WEST SUSSEX COUNTY COUNCIL CONSULTATION

TO:	Arun District Council FAO:Michael Eastham
FROM:	WSCC - Highways Authority
DATE:	18 November 2019
LOCATION:	Bridge Cottage Lidsey Road Bognor Regis PO22 9PH
SUBJECT:	AL/75/19/PL Construction of 8 no. dwellings, alterations to access and associated works - This is a Departure from the Development Plan. More information.
DATE OF SITE VISIT:	n/a
RECOMMENDATION:	Objection
S106 CONTRIBUTION TOTAL:	As previously stated

FIGURE-1.3

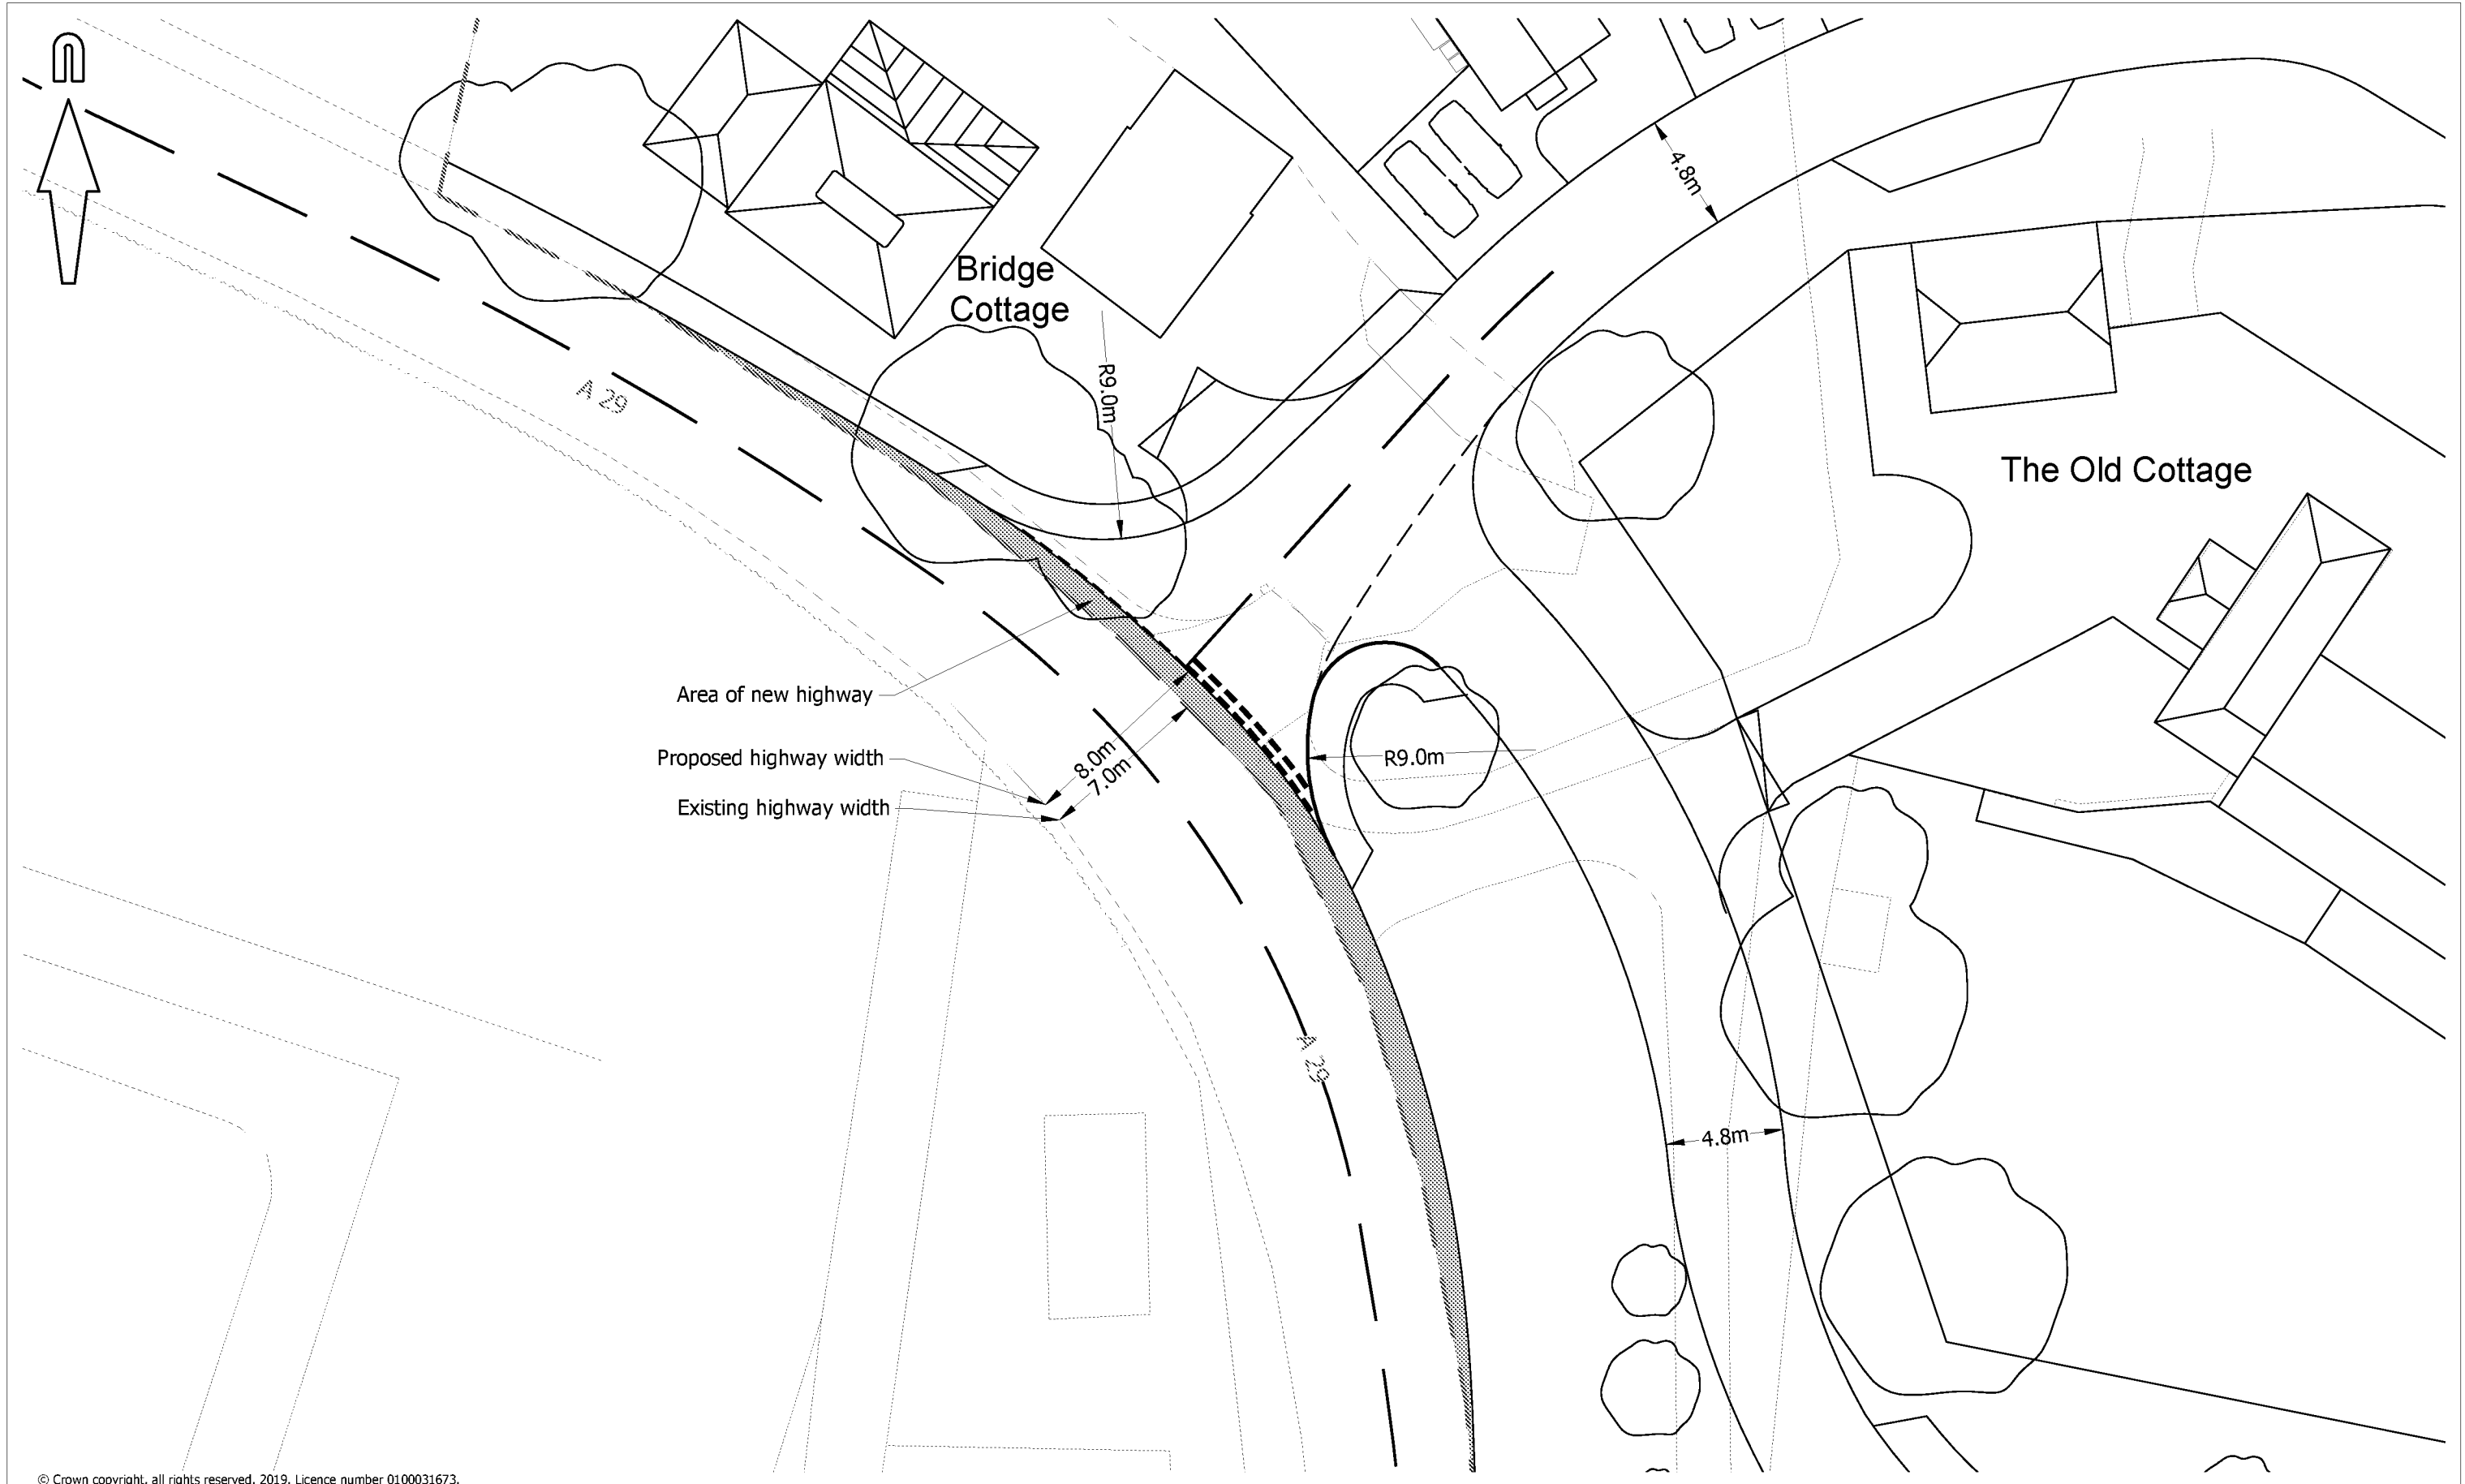
The additional tracking drawings requested by WSCC (for a large vehicle entering) are noted. The tracking does show a refuse vehicle overhanging the centre line of the access road when entering from the north. In light of the infrequent nature of this movement, and the fact that this would occur at other existing junctions, this arrangement is accepted.

scale	1:250 @ A3	drawn by	JME	checked by	KC
date	AUGUST 2019	cad file	FIGURE	suitability	rev. P1
drawing number	FIGURE-1.5

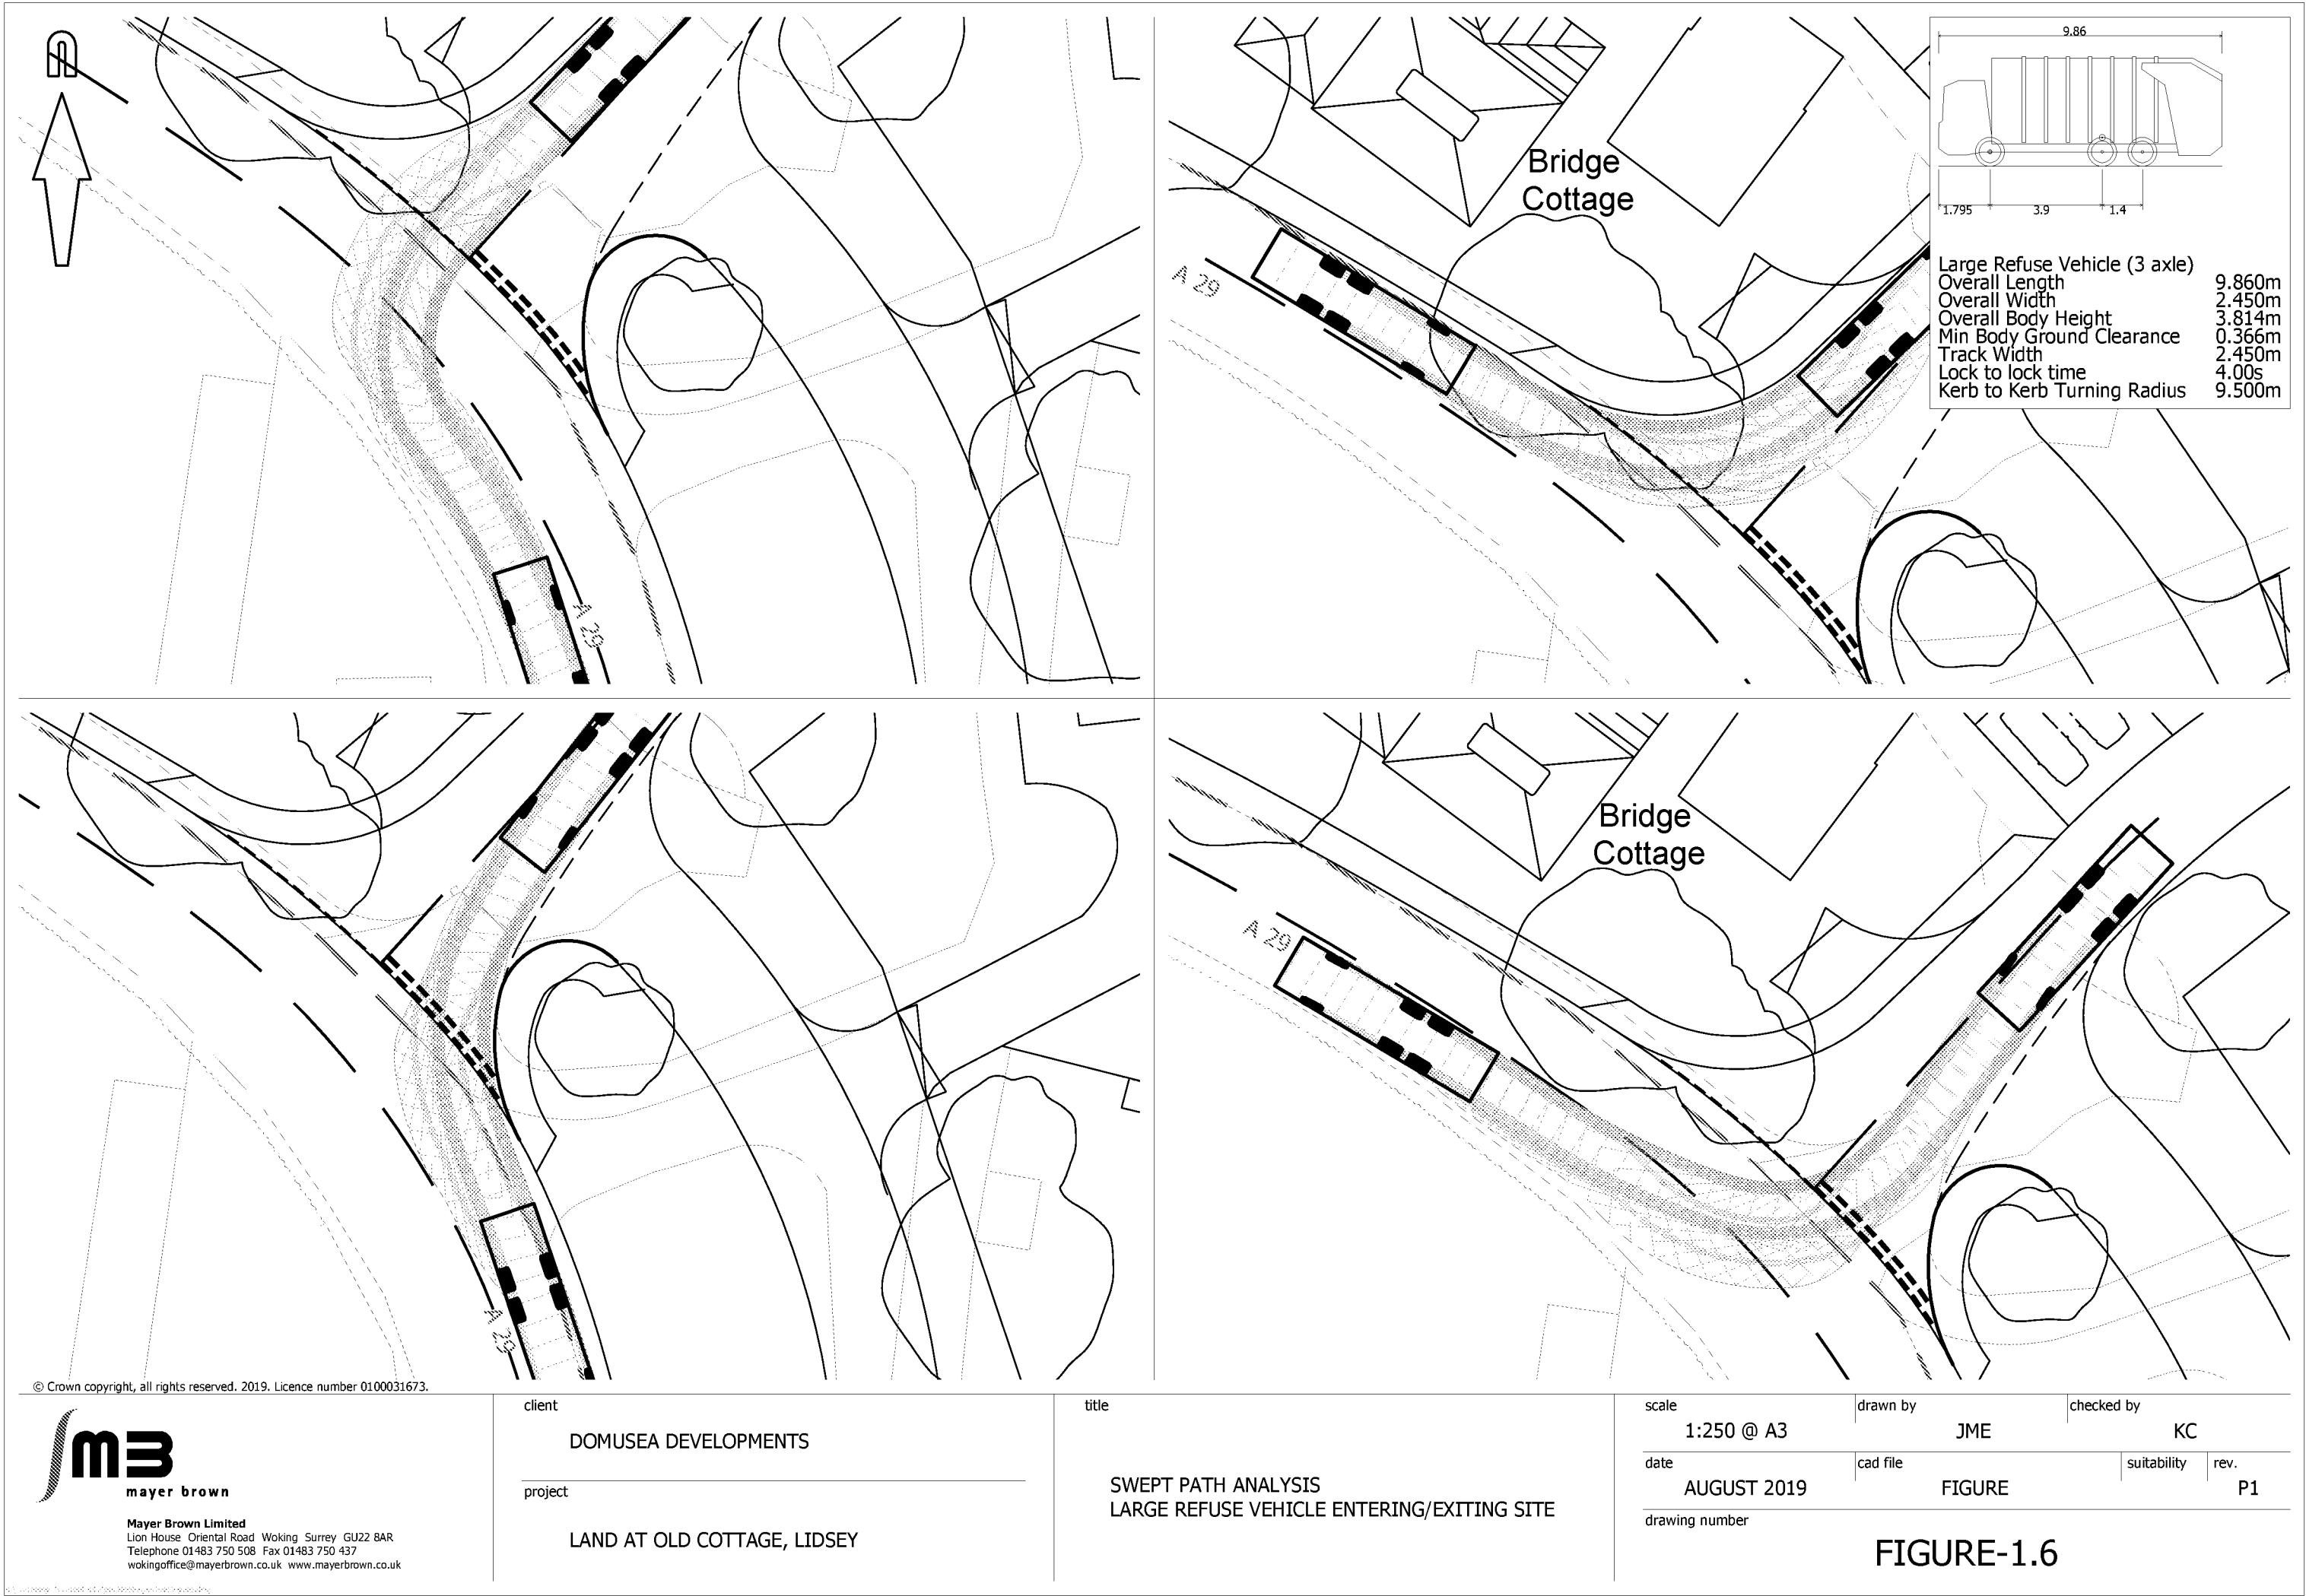
The plan (drawing number FIGURE-1.5 within appendix B of the RSA) showing the geometry of the proposed access is noted. The proposed access road width and kerb radii as shown on this are acceptable. The amended site plan as attached to the applicant's email of the 29th October 2019 is also noted. This includes the provision of a link northwards to the existing public right of way and southwards to the southbound bus stop on the A29. Whilst these links are
